Application for removal or variation of a condition following grant of
planning permission. Town and Country Planning Act 1990.
Planning (Listed Buildings and Conservation Areas) Act 1990

House:	94	Suffix:	
House name:			
Street address:	London Road		
	Long Sutton		
Town/City:	Long Sutton		
County:			
Postcode:	PE12 9ED

Erection of 9 Dwellings and Associated Works

RED MULTI
HANDMADE

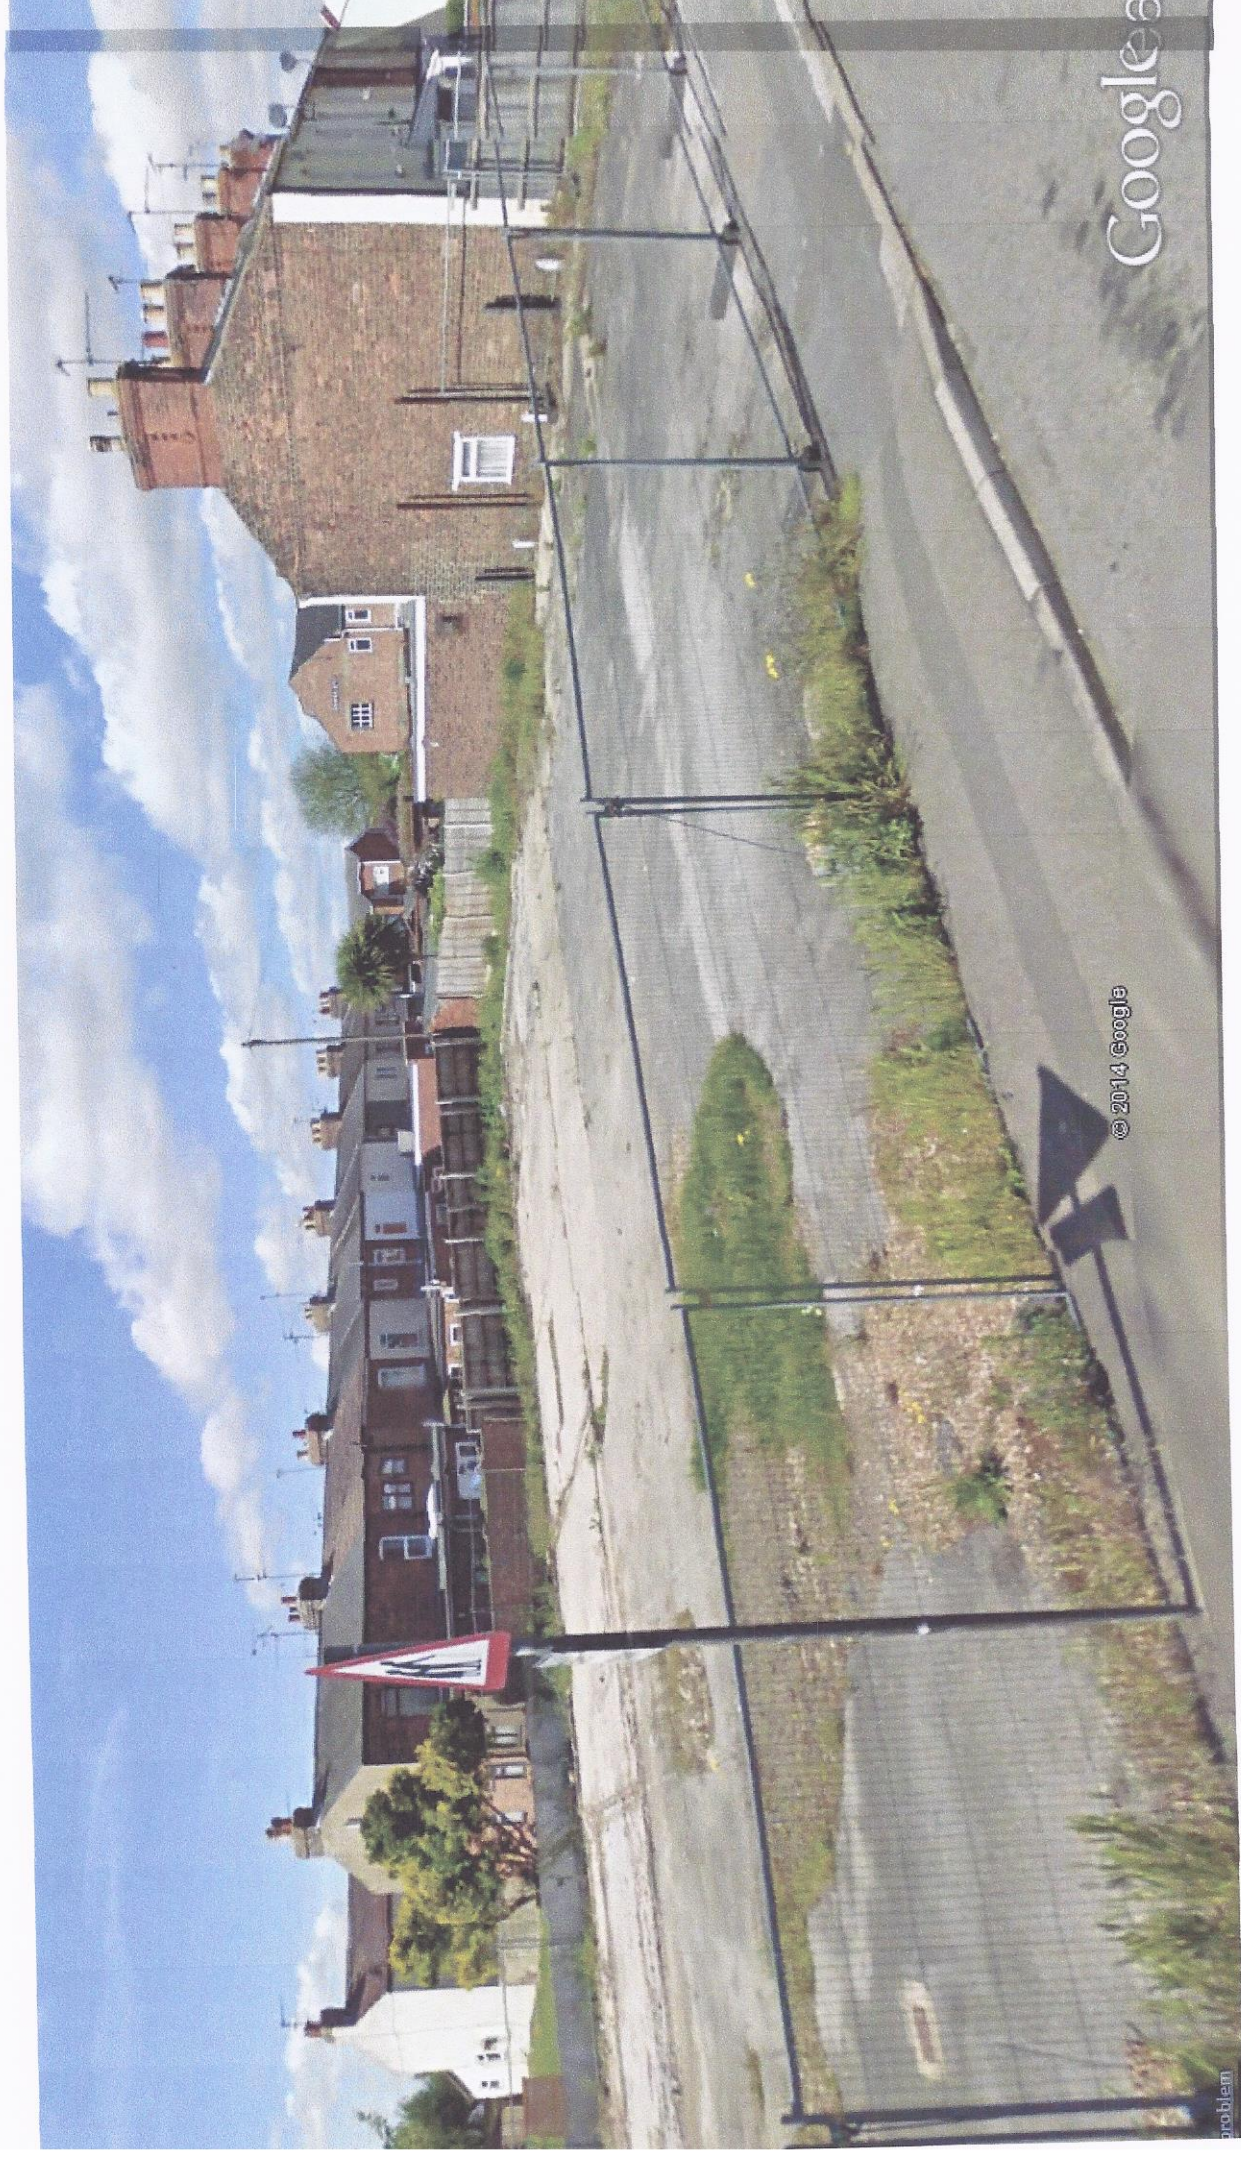
The facing bricks approved on drawing 06A (TBS - Audley Antique) are not available for several weeks.

Facing bricks to be changed to All About Bricks - Red Multi Handmade.
